Department of Primary Industries

OUT13/19709

31 JUL 2013

Atlas-Campaspe Mineral Sands Project (SSD-5012) Response to exhibition of Environmental Impact Statement

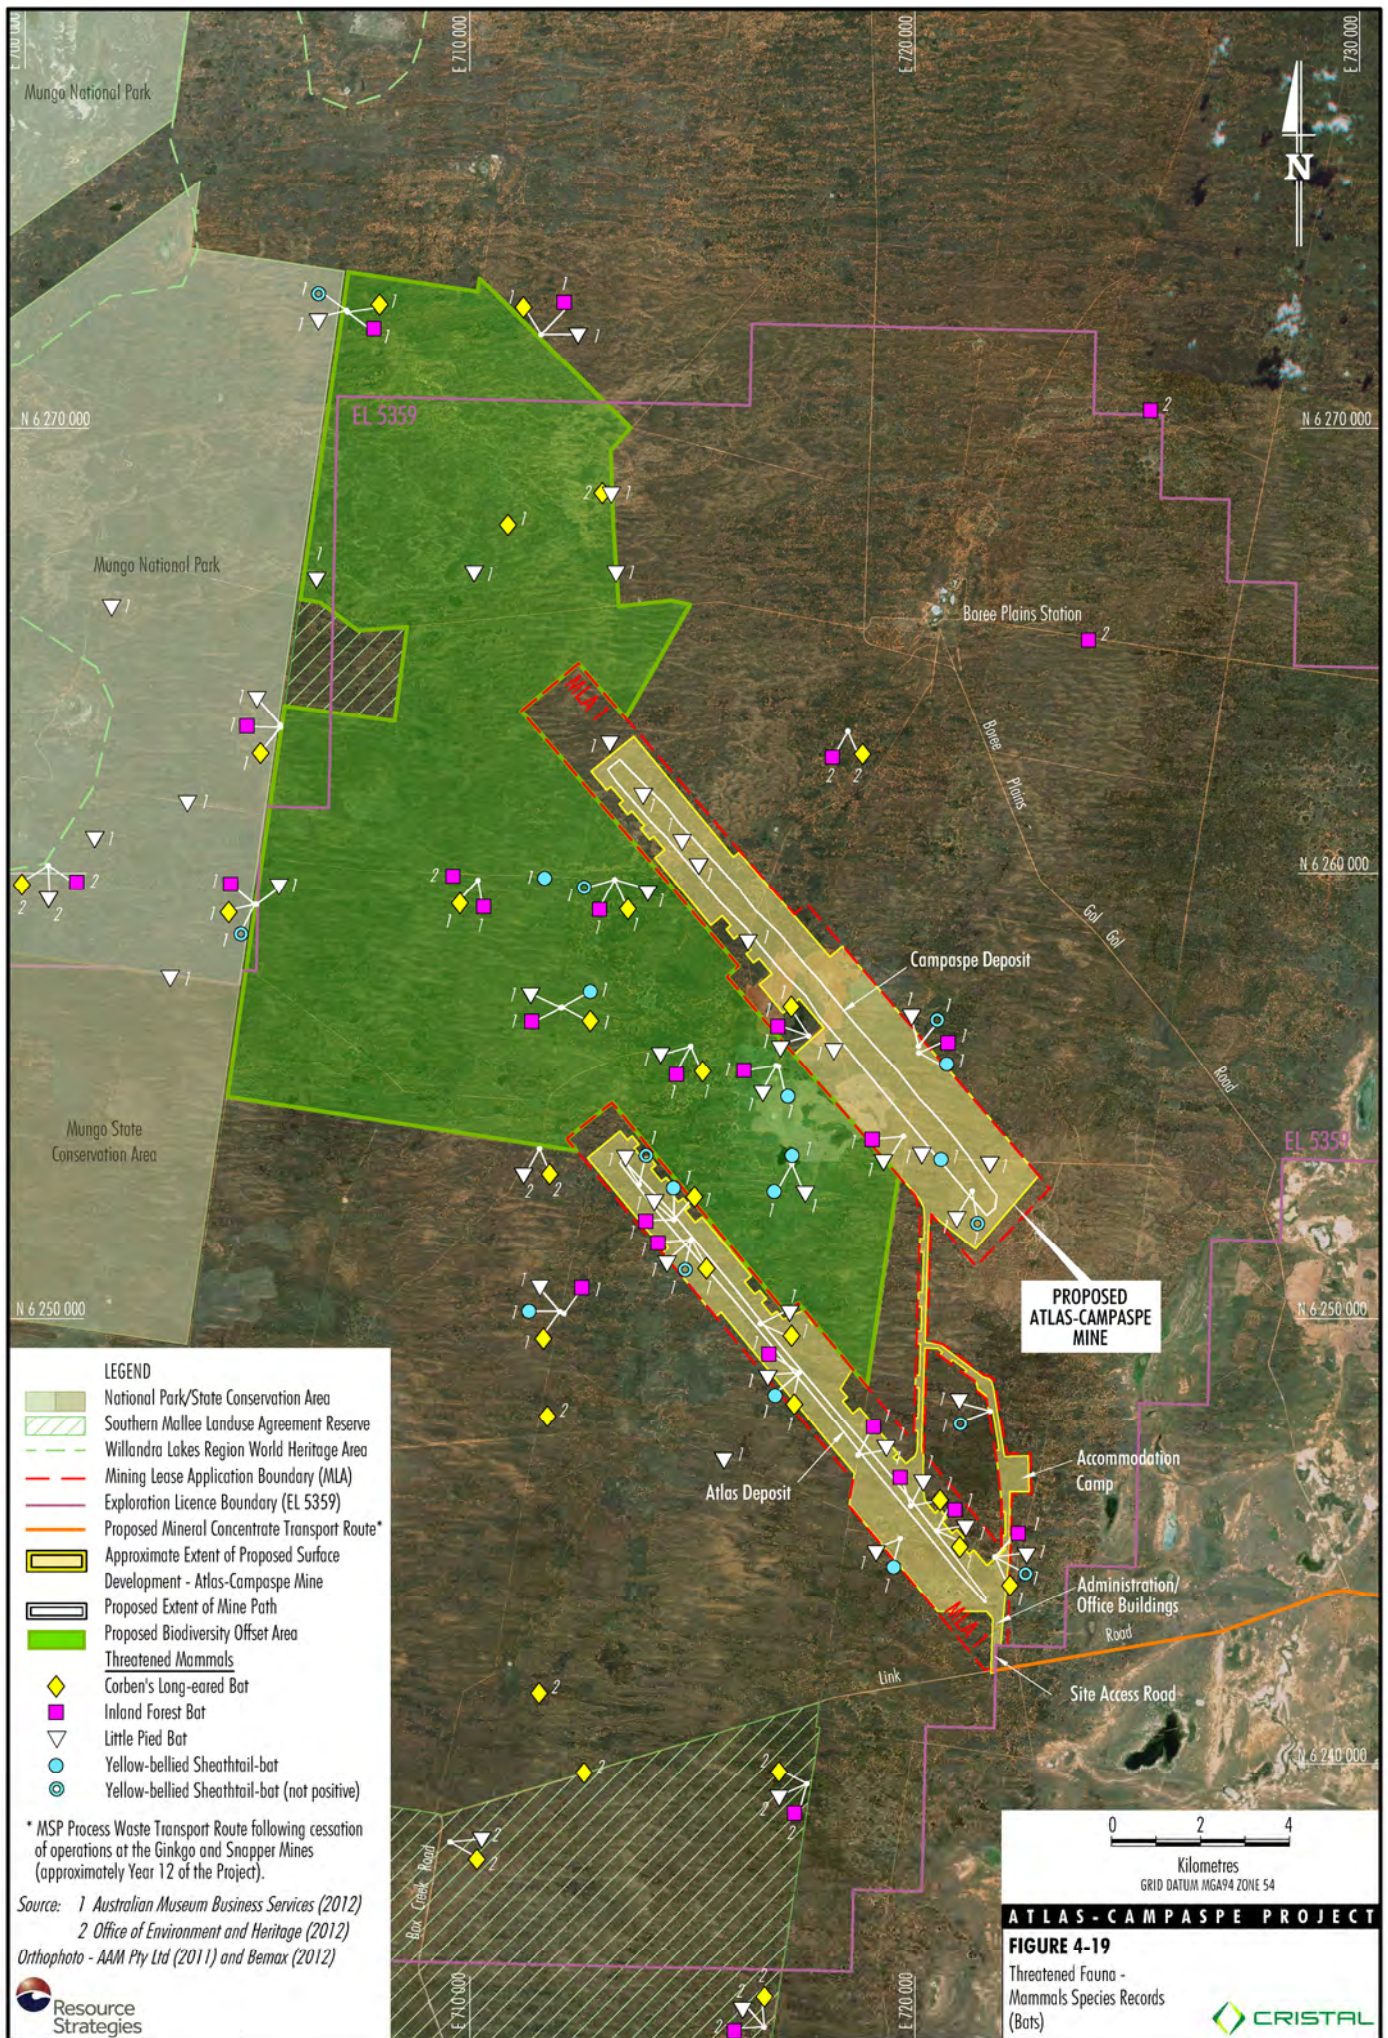
Travelling Stock Reserve (TSR) 583 (Gazetted 10 March 1884) traverses Lot 614 in Deposited Plan (DP) 761601. The proposed mine development and biodiversity offset area, shown in Figure 4-13 (Section 4, Page 4-46), is likely to encroach upon the TSR. In which case, the proponent will need to negotiate with the relevant Livestock Health and Pest Authority (LHPA) regarding site access and occupation. This is not stated in the EIS.
